## **Landscape and Visual Impact Assessment - Review**

**Dean Moor Solar Farm**

**Cumberland Council**

*Issue: Dean Moor Solar Farm LVIA Review\_FINAL\_170625*

- LEGEND**
- Order Limits
 - EXISTING FEATURES**
 - Existing Woodland/Scrub (Broadleaved)
 - Existing Woodland (Coniferous)
 - Existing Woodland (Out of Order Limits)

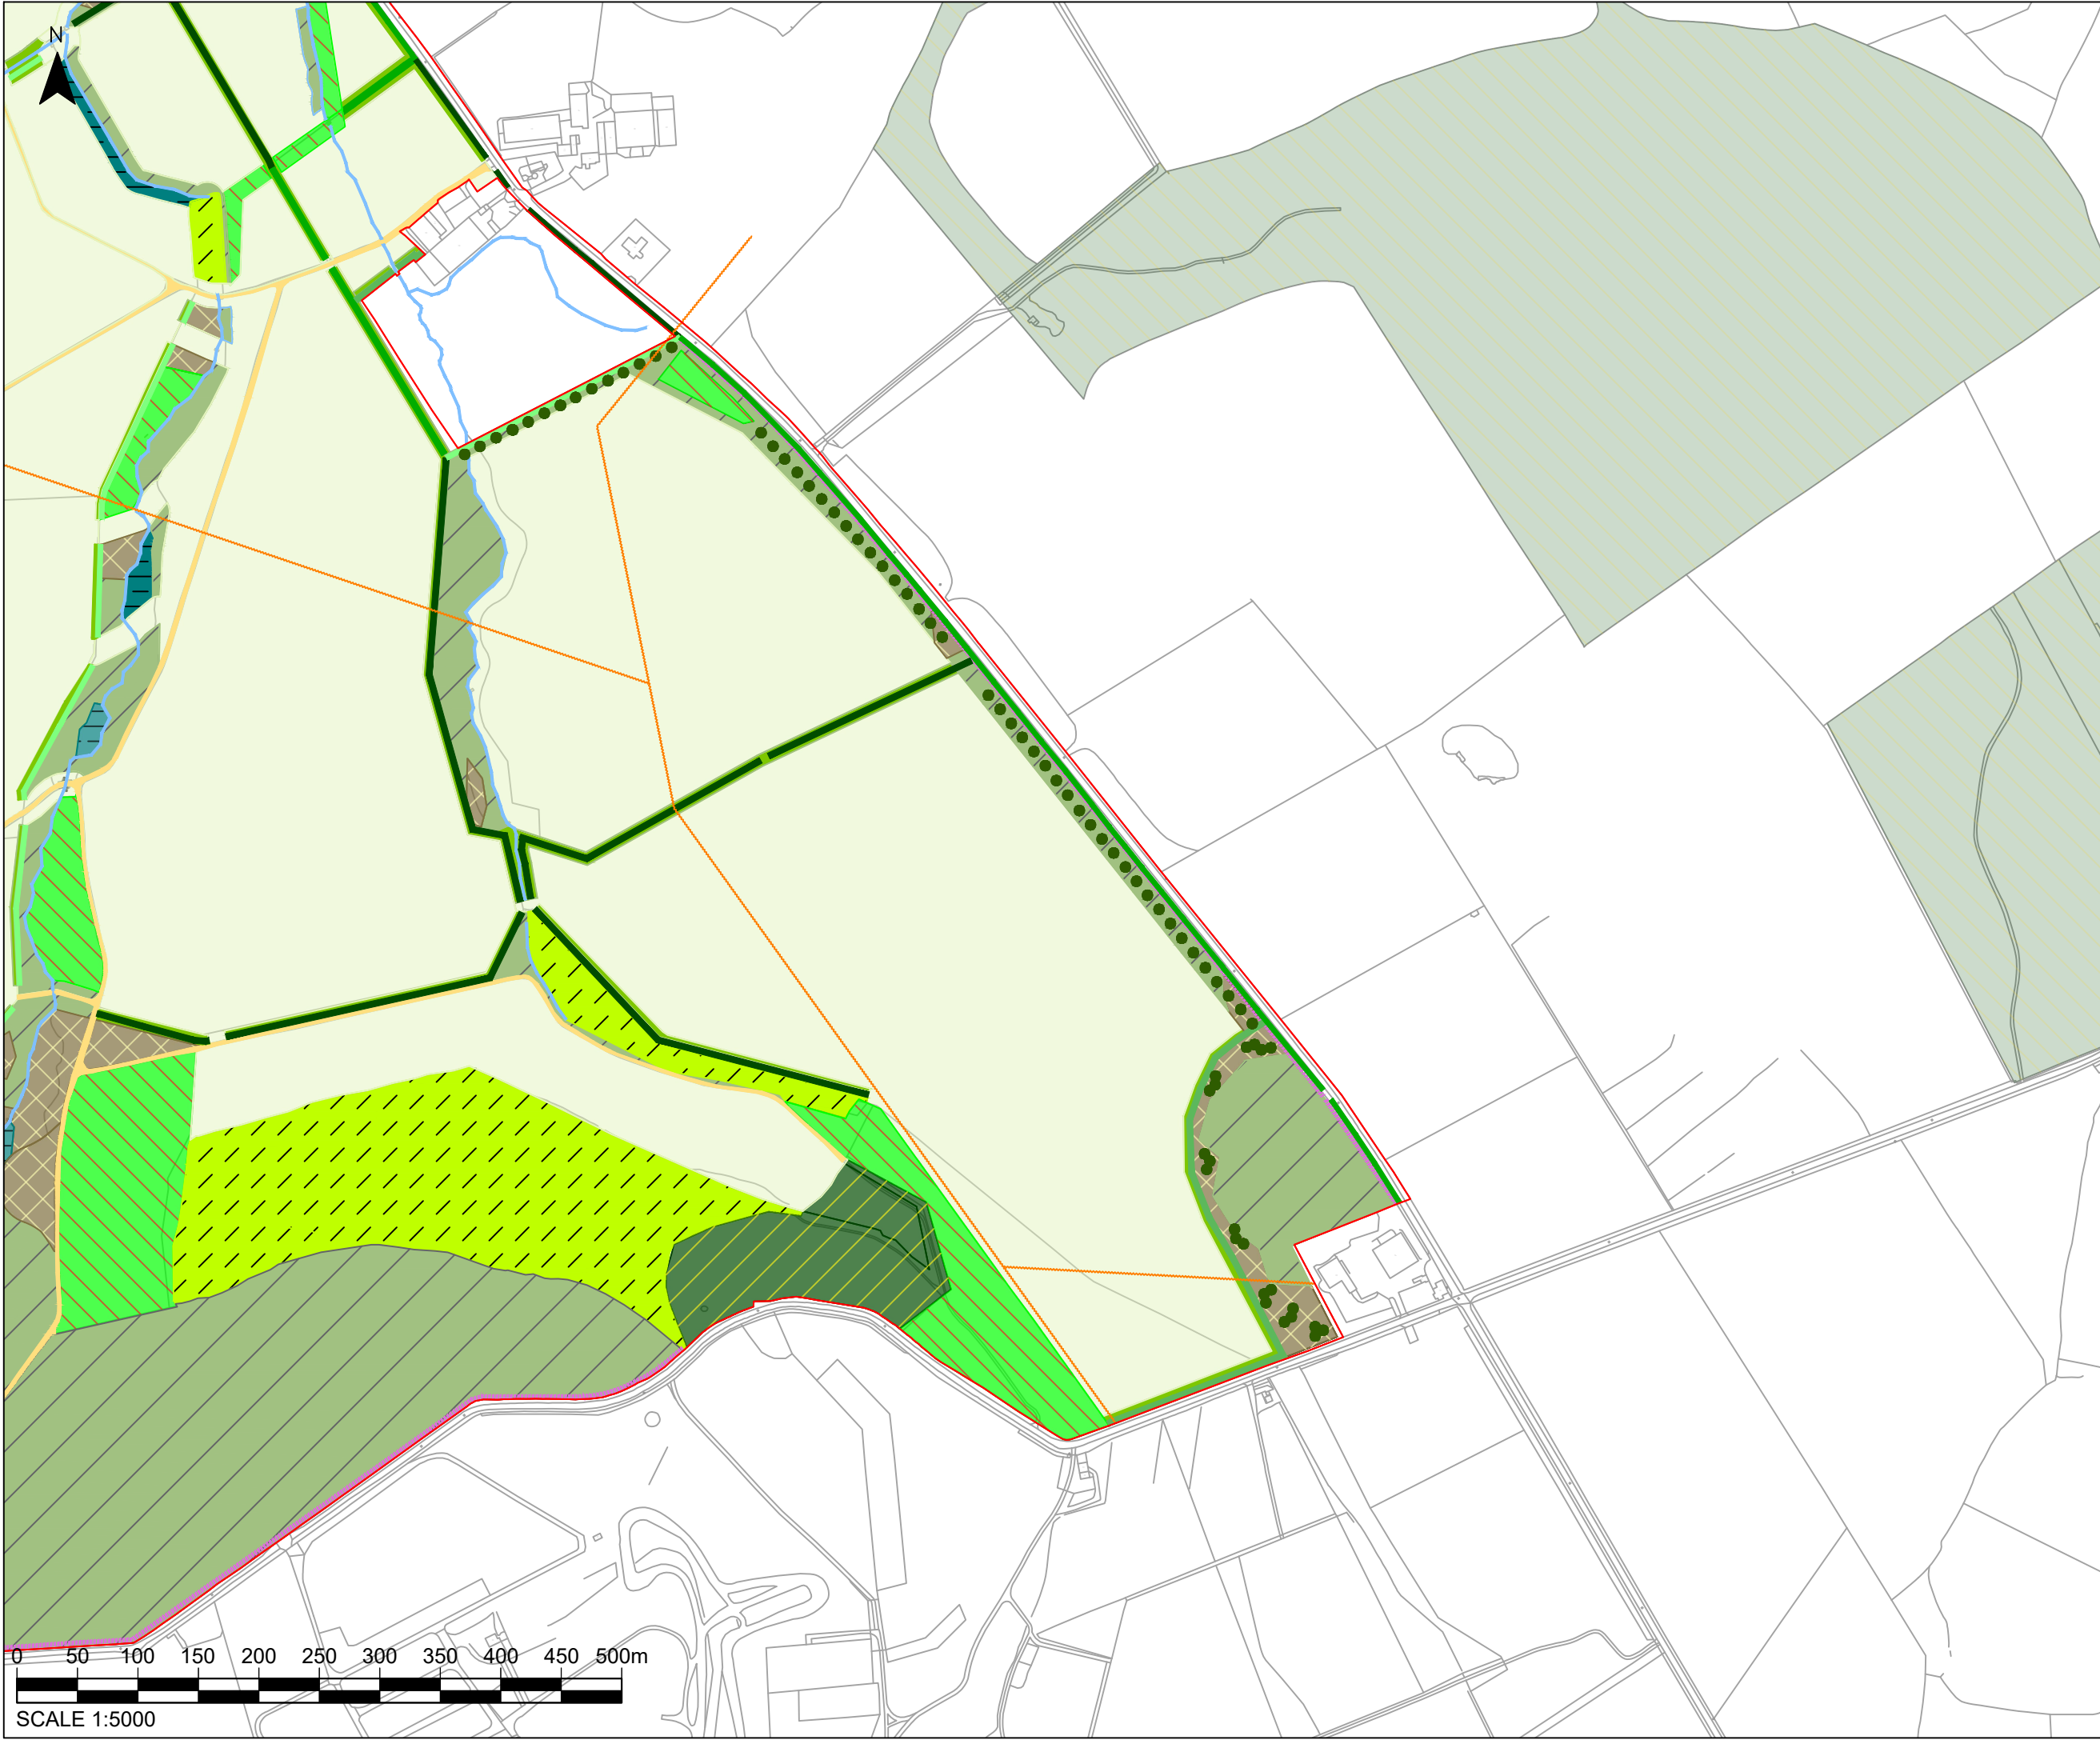
Mitigations proposals are shown in the Landscape Strategy Plan (Figures 7.6.15) and described in para 7.5.3 of the submitted LVIA.

The mitigation measures proposed seek to strengthen the existing landscape features where possible. This includes the infilling and enhancement of existing, enhancing existing woodland and scrub areas as well new woodland planting (along road edges (in the north) and watercourses in the southern area. There is also some hedgerow tree planting along Branthwaite Edge Road on the eastern boundary. These measures would, over time, help to reduce the visibility of the Proposed Development by screening views from the roads which run adjacent to the Site. Further planting of extra woodland and/or hedgerow trees would be suitable along the west of Branthwaite Edge Road.
